Re: New Office/ Ware House
541 Airport Dr. NW
Conceptual Traffic Circulation Layout for DRB Approval
Architect's Stamp 07-12-22 (K10-D023K)

**Re: NEW OFFICE/WAREHOUSE
541 Airport Drive NW
Traffic Circulation Layout
Architect's Stamp None (K10-D023)**

Subject-New Office/Warehouse- 541 Airport Drive NW
Traffic Circulation Layout Review

1 SITE PLAN- PHASE TWO
1"=50'

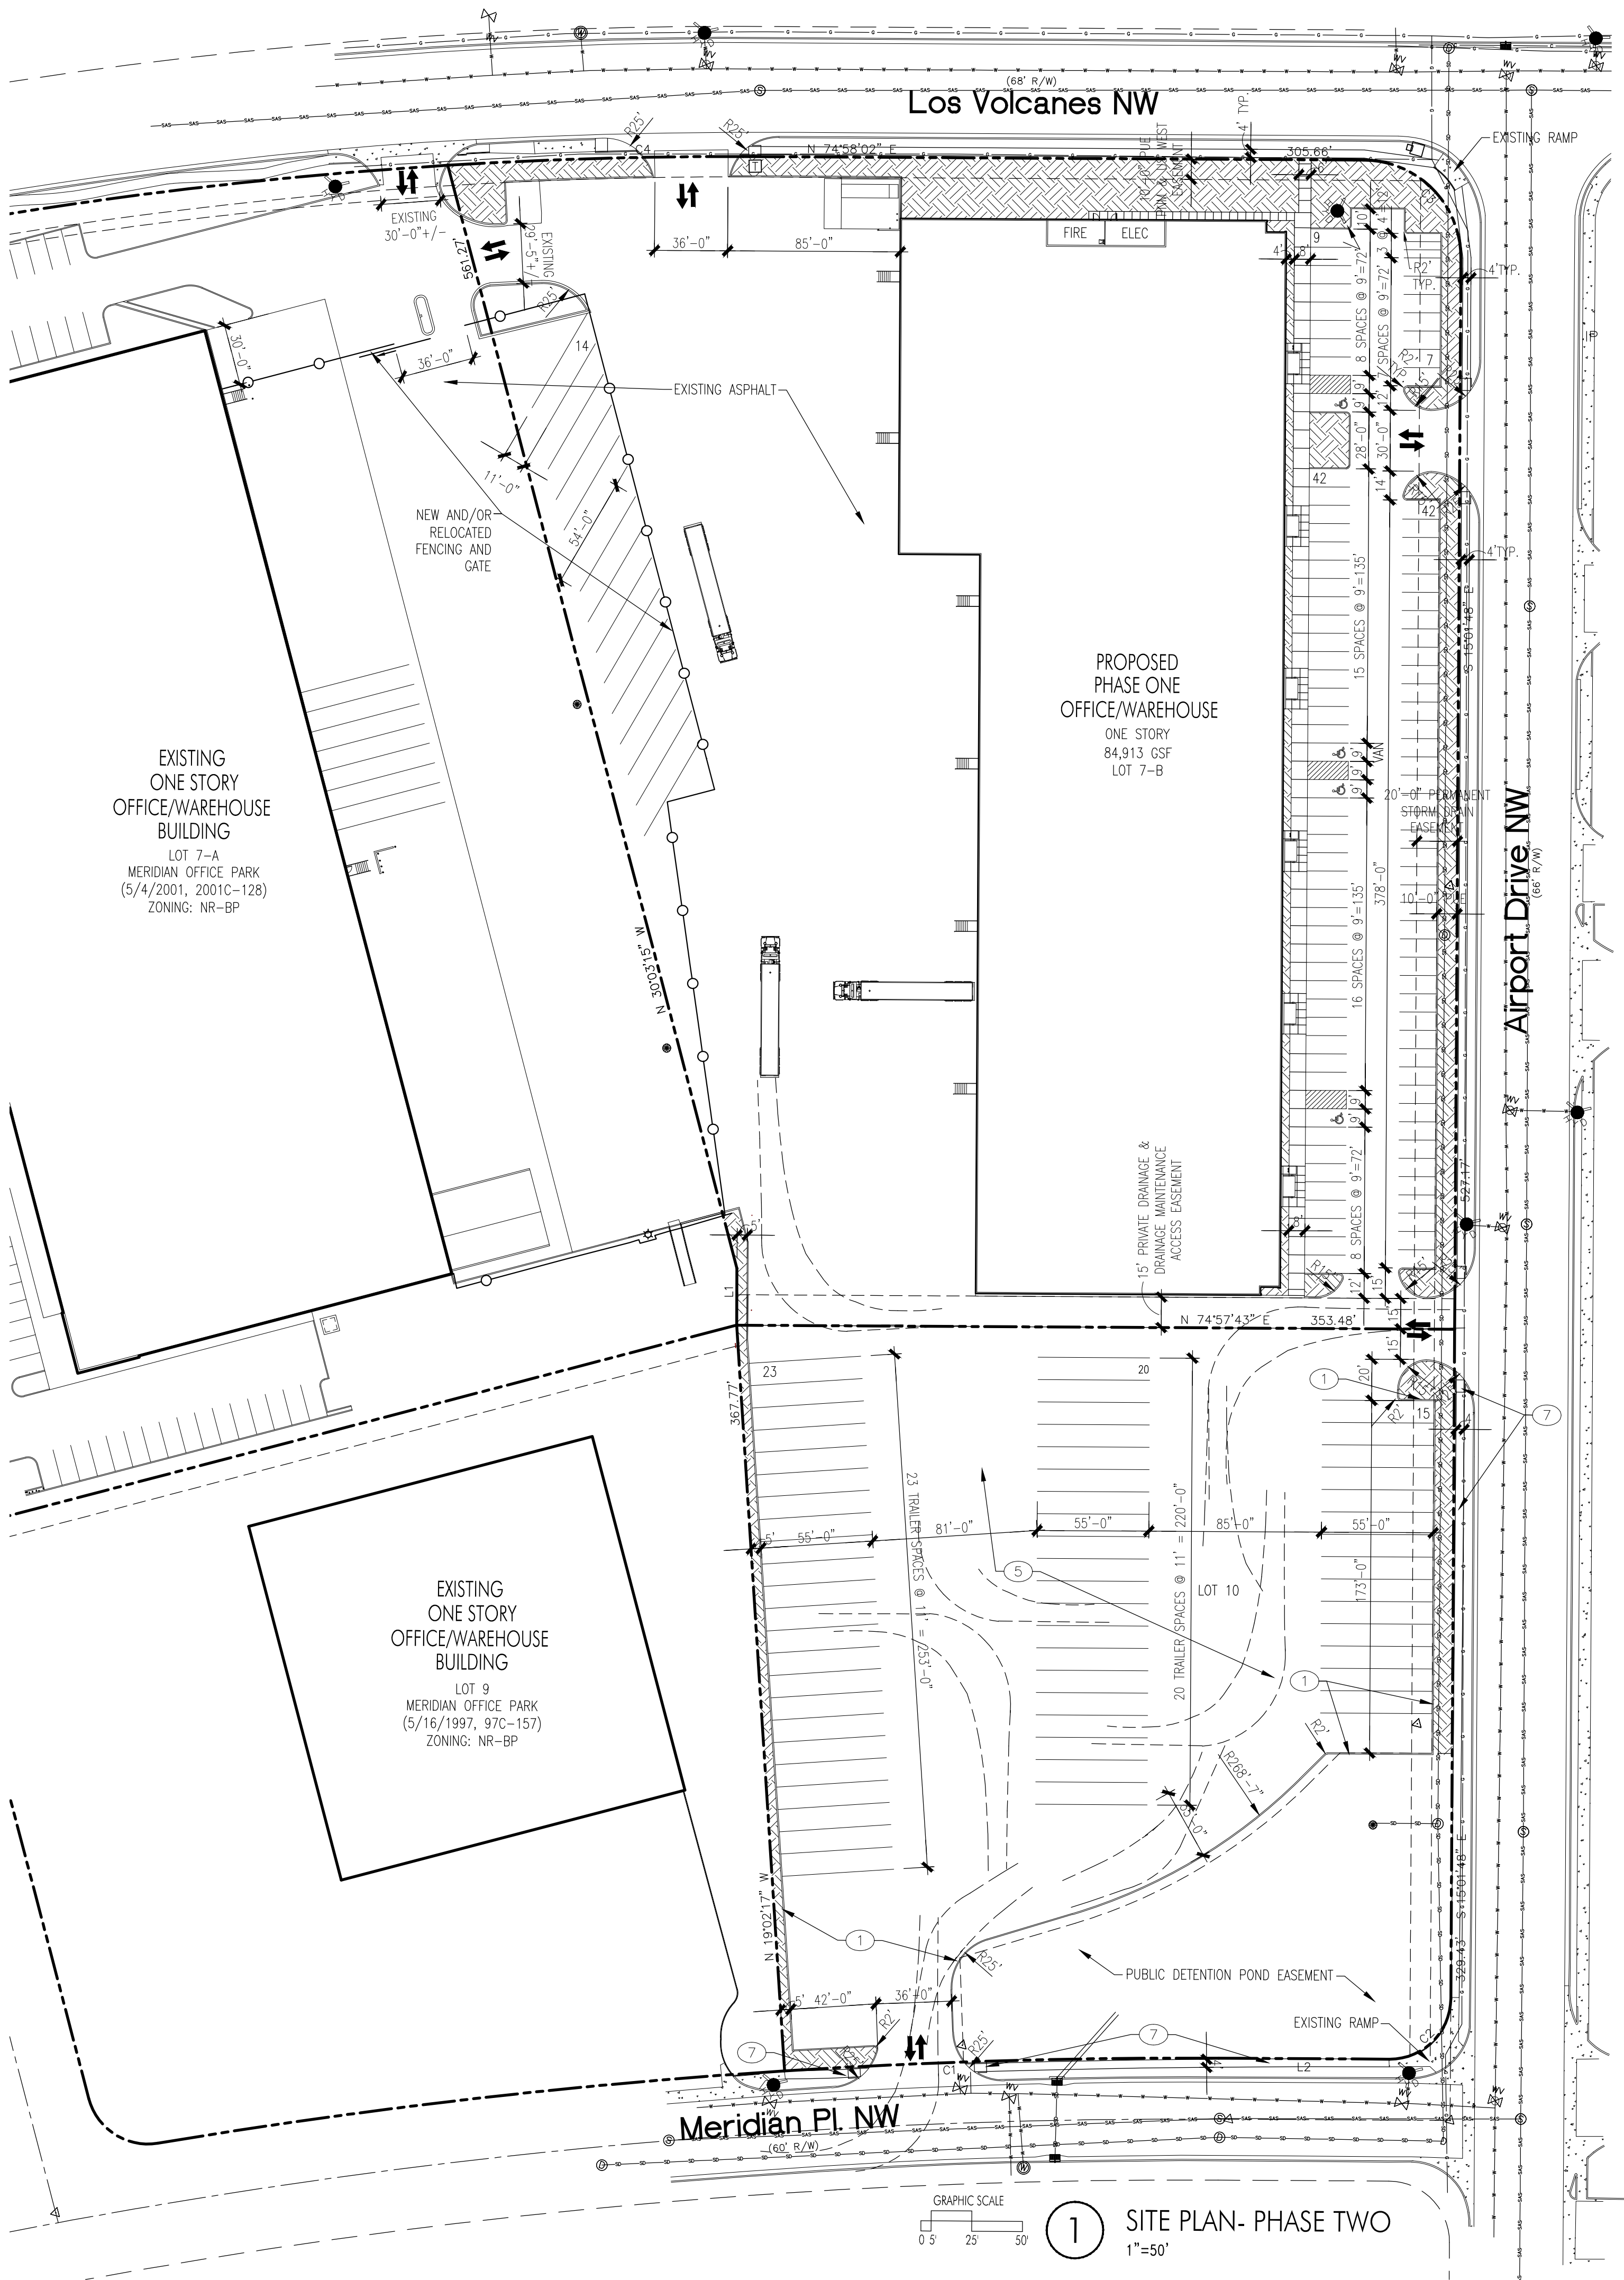
2. Clarify the extents of the current phase 1 versus phase 2. Are you proposing phase 2 as part of this submittal ? Explain since phase 2 is on a different lot and will required a separate submittal and fees. I will not comment on sheet SDP-2 until the appropriate action is taken for the submittal process.

Project Description- This project will involve three separate lots that are all owned by the same entity, lots 7A, 7B and 10. Cross access and drainage easements exist on lots 7A & 7B while lot 10 will be added to this cross access easement with this project. The project will also be divided into two phases shown separately on sheet SDP-1 and SDP-2. Phase one shown on SDP-1 will involve the new building and all site improvements on Lot 7B. Phase two shown on DSP-2 will involve developing lot 10 for trailer parking for the two buildings on Lot 7A and 7B. Phase two will also involve some minor reconfigurations to the existing truck court on 7A and some docks on 7B. Please refer to the drawings for details of the phasing.

1. Parking is shown per the IDO.
2. Refer to the project description above as well as more detailed noting on the plans. Also attached is the draft access easement.
